Response for : Malatesta Public Comment Letter dated January 2024

ARBORIST Memo

Report Date:
March 3, 2024

Site Address:
3036 67th Avenue SE
Mercer Island, WA

TREE RETENTION PLAN
3036 67TH AVENUE SE
SITE PLAN
PARCEL 2174501025
CITY OF MERCER ISLAND WASHINGTON

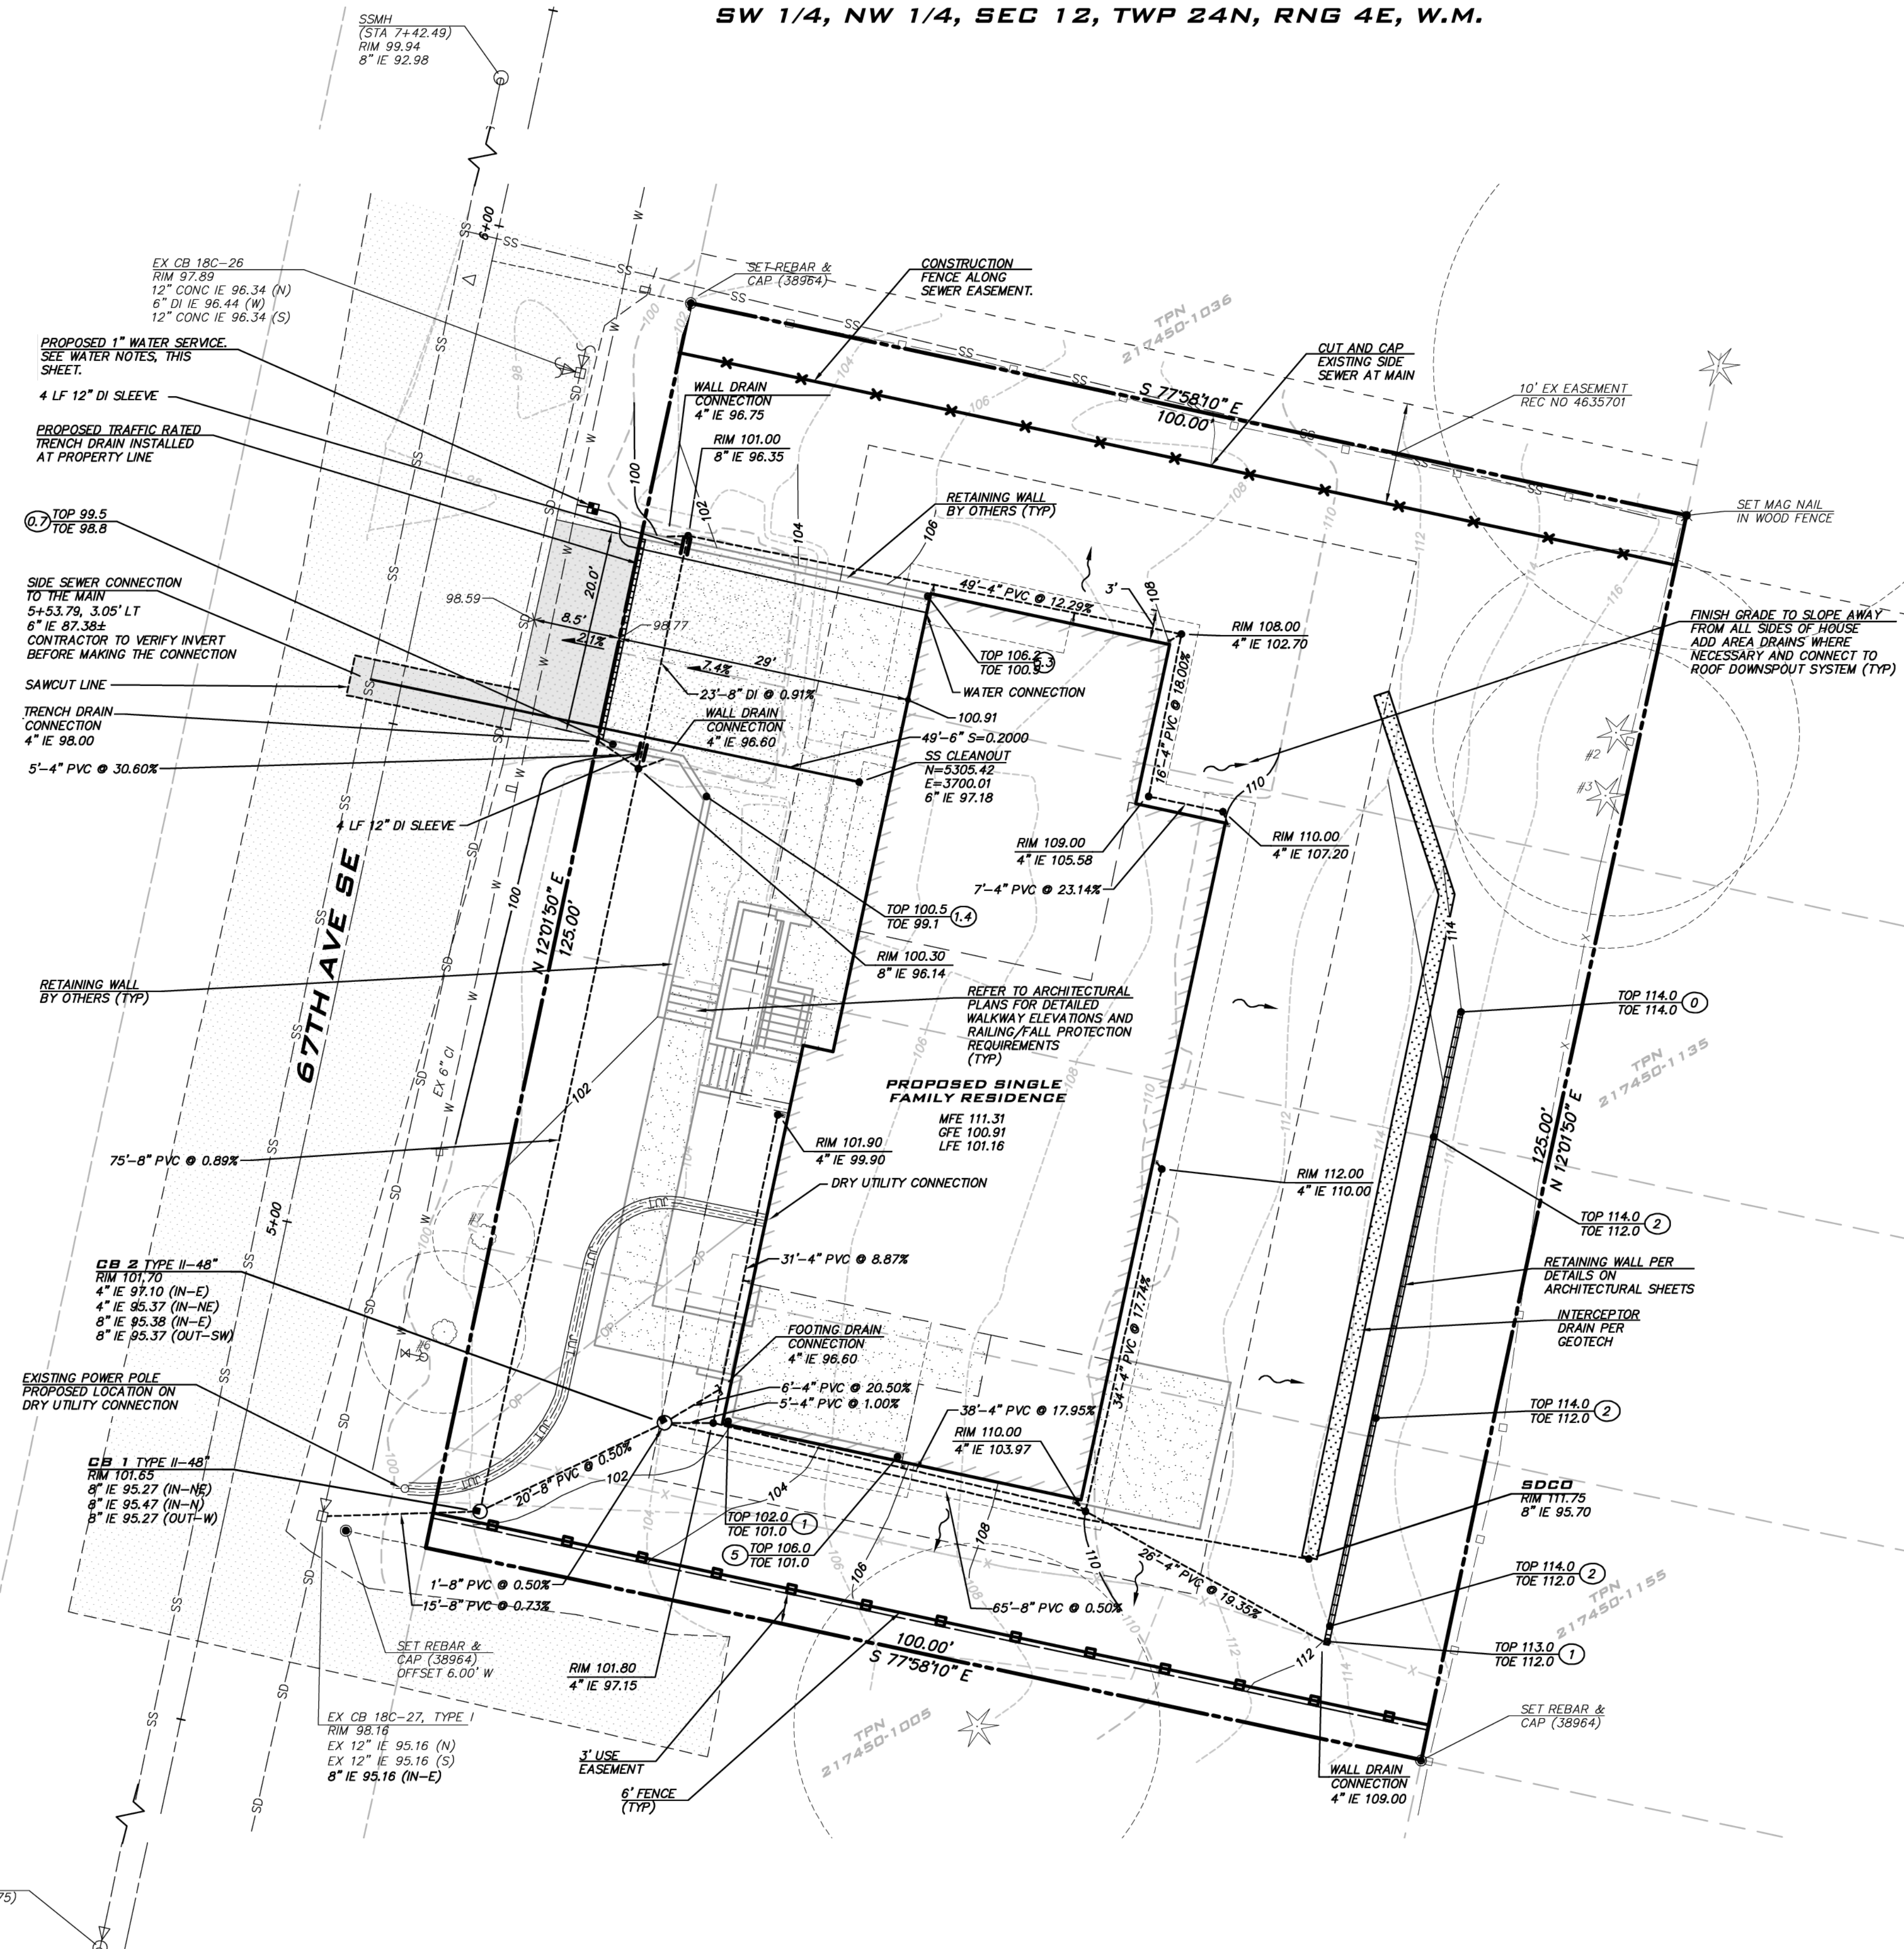
Ron Malatesta is concerned about the dangers of trees 2&3 as detailed in the original comment letter dated 2023. Below is an expert for a memo prepared by Tom Quigley the arborist for this project. I have also included the full copy of the memo for the Malatesta's records.

The invasive ivy was removed and both trees were climbed to perform inspections of the old topping cuts. The neighbor to the immediate east came out and shared with us that he had lived in the home for 50 years and that the trees had been topped prior to that. While he had submitted information related to a large limb falling from the trees, I believe I understood him to say that the particular incident had occurred many years ago. The following two photos were taken February 29, 2024. They show that the topping cuts have completely 'healed' over with no decaying wood or decay column present. There were no other obvious conditions that would indicate the presence of decay. While in Tree #2, we removed an 8" diameter limb that had grown to become a co-dominant stem that appeared unsightly. We also removed three limbs that were over-weighted and hung precariously downward from Tree #3. No climbing or limb removal was done above about 30' in the trees.

I visited the February 29, 2024 to re-assess Tree #2, after invasive ivy was removed, together with a further assessment of Tree #3, in light of comments from City arborist John Kenney and from neighboring property owners.

City arborist John Kenney also indicated that I should suggest an alternate species to the planned planting of Western Red Cedar trees in the backyard of the subject property. I have reviewed plan set A1.1 and agree that replacing four(4) of the four Western Red Cedar trees with Vine maple will make for happier uphill neighbors and will provide a better planting pallet, long-term.
